From: MarkHobbs [REDACTED]
Sent: 15 November 2021 12:22
To: Sarah Burrow; Planning.Responses
Cc: Simon Davis; Paul Cann; Glynn Curtis
Subject: RE: Planning Consultation on: P/146/21/DOC
Attachments: Barfoot - Sefter Barn FC2846.02F SW Drainage.pdf; Barfoot - Sefter Barn FC2846.05A - Dr Details.pdf; ALT-151121-201-01 A.pdf; ExportsHQT-081427 _design.pdf

From: Sarah Burrow <Sarah.Burrow@arun.gov.uk>
Sent: 11 November 2021 16:52
To: Planning.Responses <Planning.Responses@arun.gov.uk>
Cc: Simon Davis <Simon.Davis@arun.gov.uk>; Paul Cann <Paul.Cann@arun.gov.uk>
Subject: RE: Planning Consultation on: P/146/21/DOC

Engineers Comments Regarding Surface Water Drainage

Description of Works: Approval of details reserved by condition imposed under P/38/21/PL relating to conditions 2-surface water drainage scheme, 4-Landscape & Ecology Maintenance Plan & 5-landscape scheme.

PROJECT	BARN EXTENSION BARFOOTS - LITTLE SEFTER PAGHAM RD, BOGNOR REGIS W SUSSEX, PO20 1LN			
	PROPOSED SW DRAINAGE LAYOUT			
DRAWING	FC2846/02			
	REV C			
SCALE	1:125			
	DATE	JAN 20	MH	CHKD -

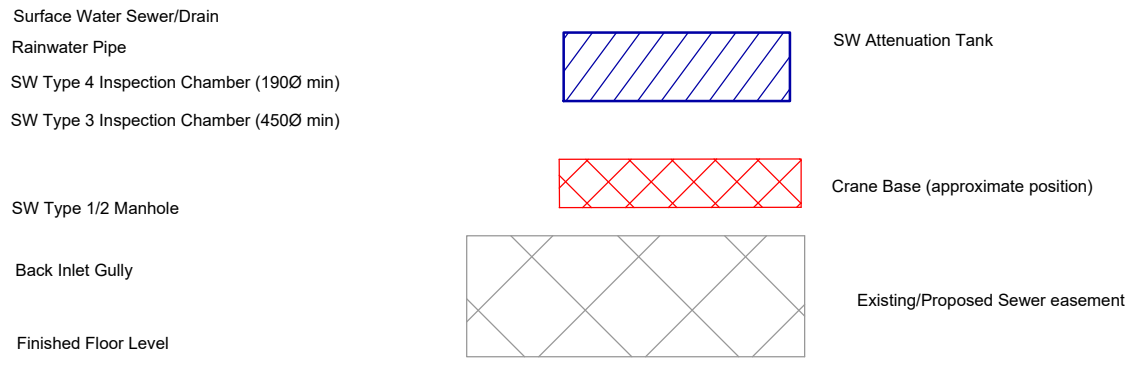
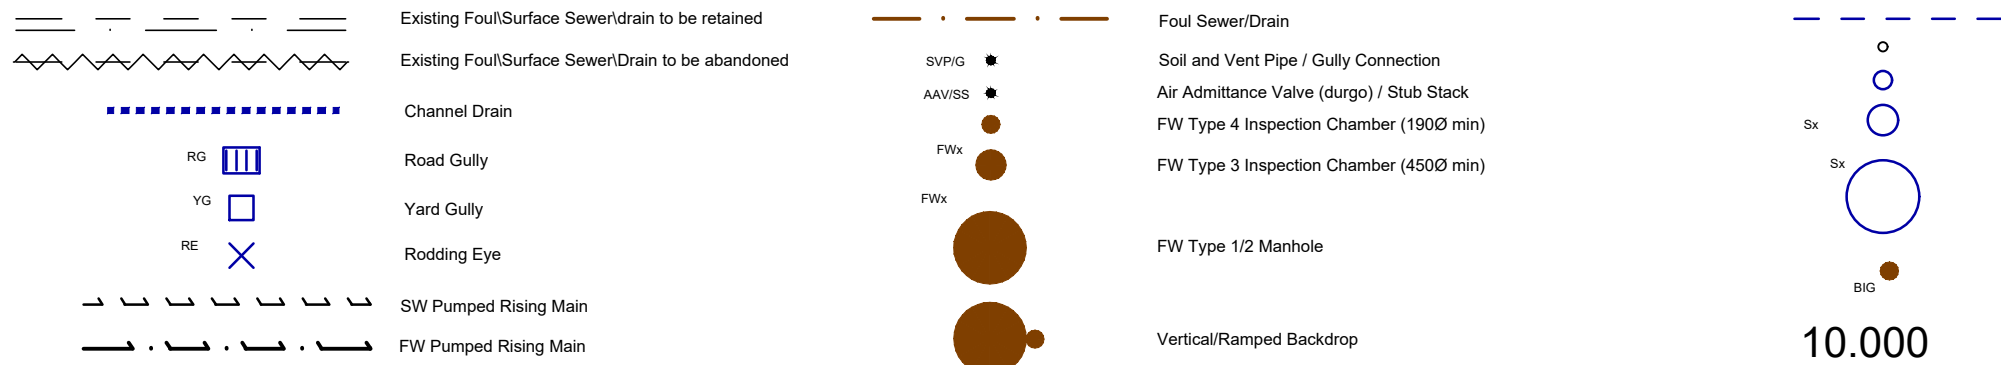
2. On the Drainage Layout there is a 'Note the following' The second note relating to the Hydrobrake needs to be adjusted for the new Hydrobrake limiting flow to 2l/s. – Noted and Updated
3. Please add a note that all pipe junctions (not connected via manholes) need to utilise oblique junctions. Noted and Updated
4. Please include the width of the base and the width of the top of the pond (in the absence of a site specific cross sectional drawing or a setting out drawing) on the drainage layout. Noted and Updated

SHE-0076-2000-0400-2000
 Hydro-Brake® Optimum

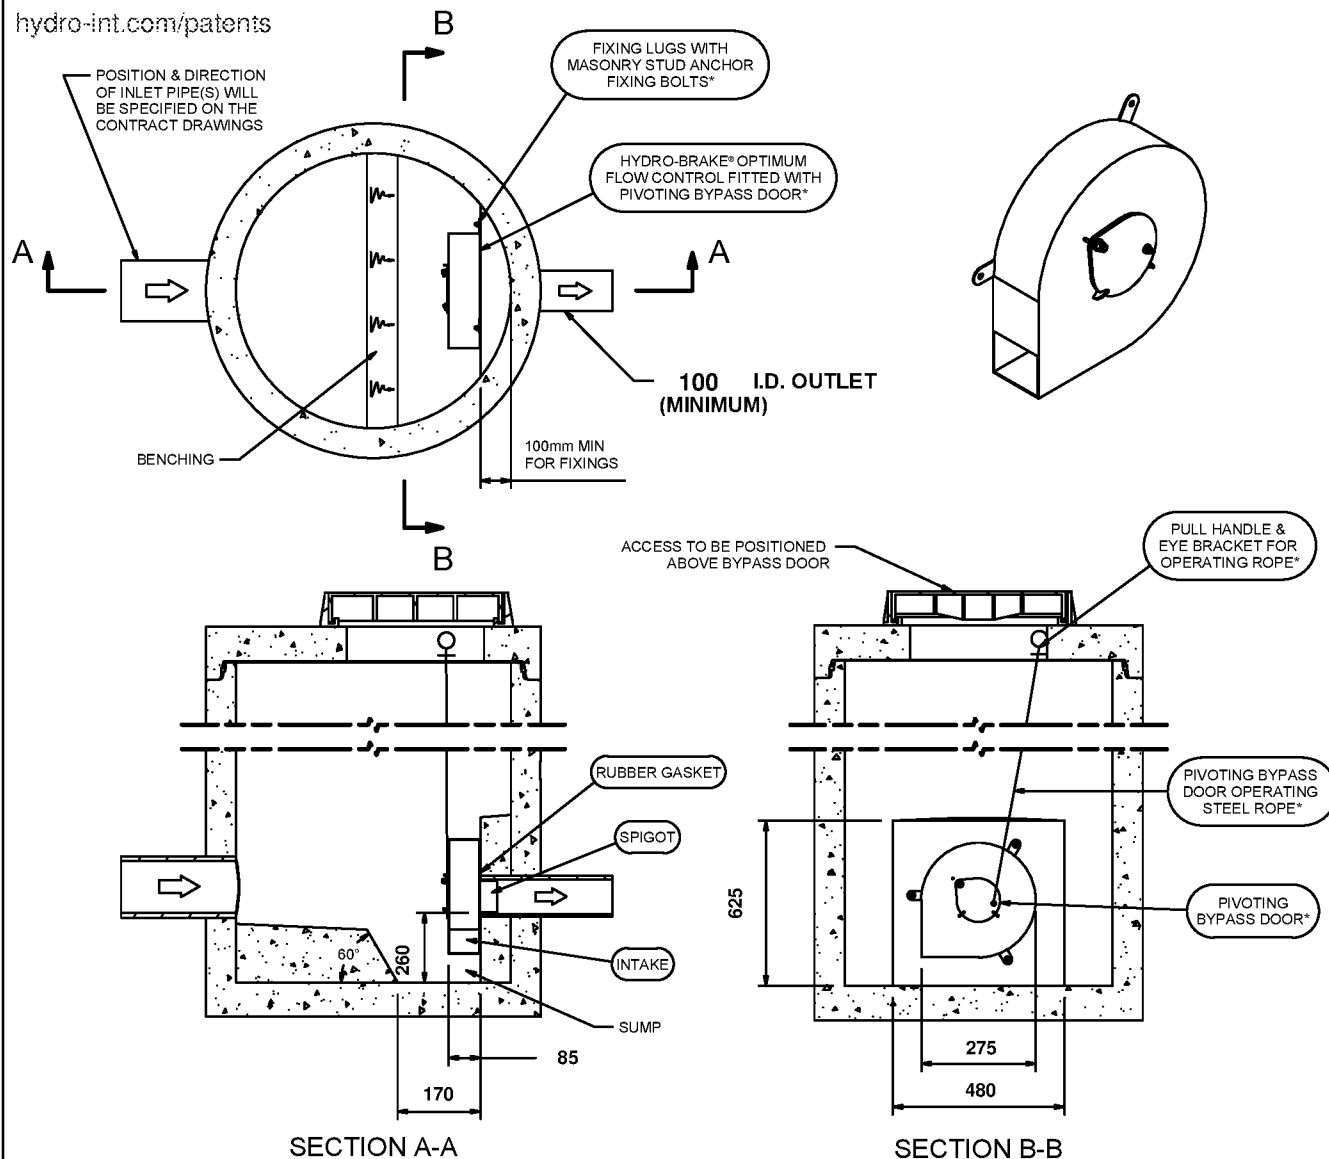
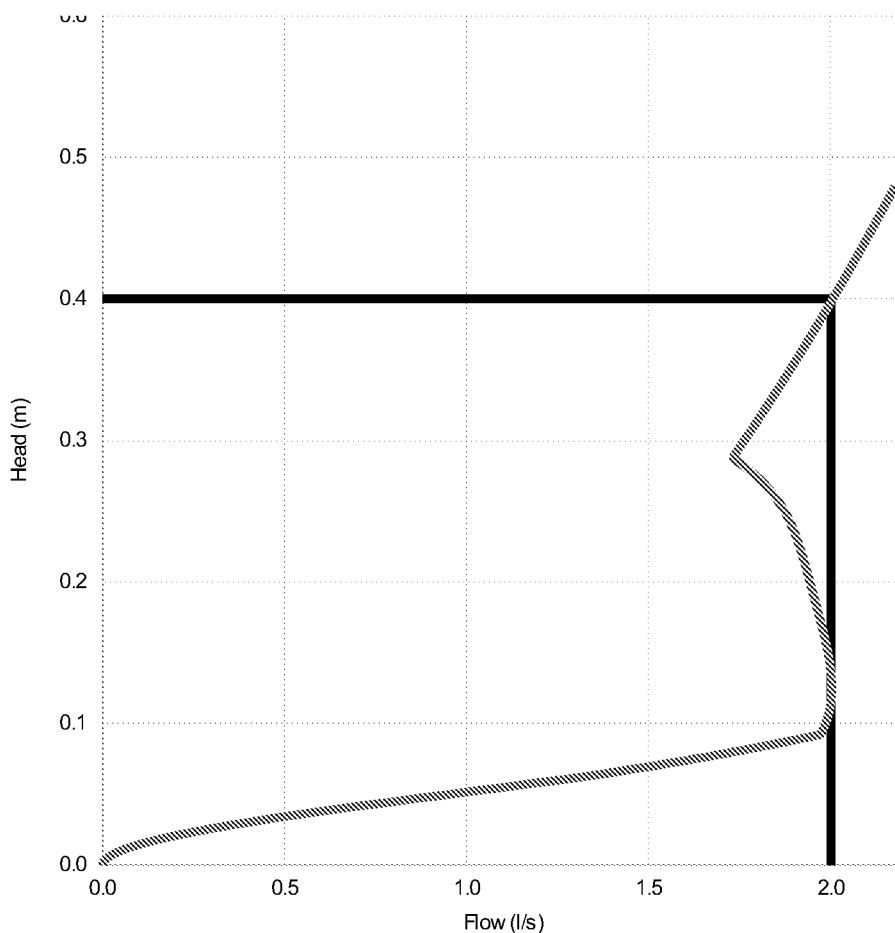
7. Please provide a site specific Hydrobrake detail. Please reference the Hydrobrake on the detail drawing and include the following: *Noted and Updated*
- a) Invert level and cover level.
 - b) Incoming and outgoing pipe diameters.
 - c) No dimensions should be 'tbc' – please clarify.

Drainage
Highway Swale

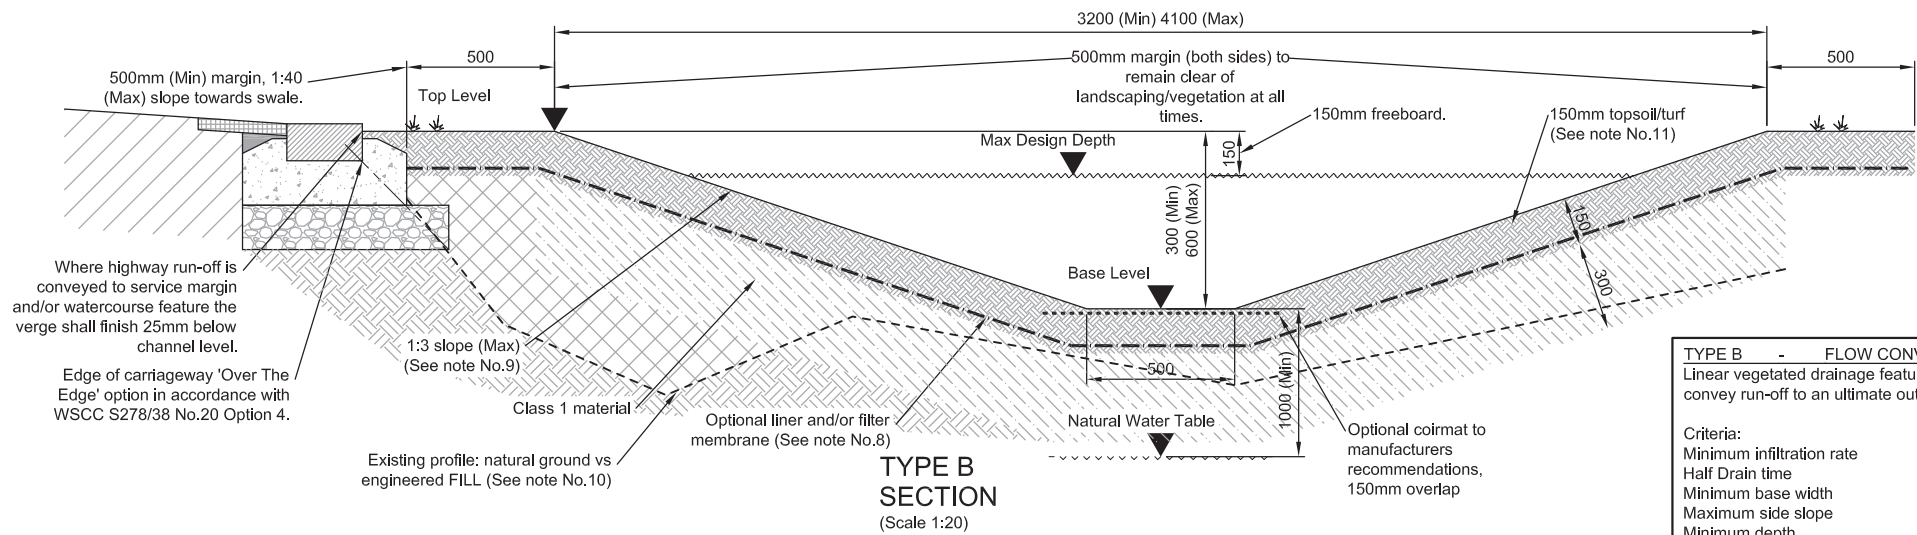
5. Dependant upon the response to point 1 further detail may be required regarding the membrane for the pond (permeable/impermeable) and possible floatation mitigation.

The storage feature is proposed to be constructed in accordance with WSCC S278/38/26 A Drainage Highway Swale detail. The detail highlights an optional liner and or filter membrane (see note No 8) – which states – 'Lining/membranes will be required if location in area of high pollution risk or risk of contamination.' Given this location is clearly not affected by these factors, no liner or filter membrane is proposed.

In addition, with ground water 2mBGL then floatation is not an issue. Given the proximity of the watercourse, the water level within the watercourse probably represents the adjacent GWL most accurately.

Providing no liner/membrane will enable the first flush of water entering the storage feature to be absorbed/infiltrate into the soil – providing a more SuDs like feature
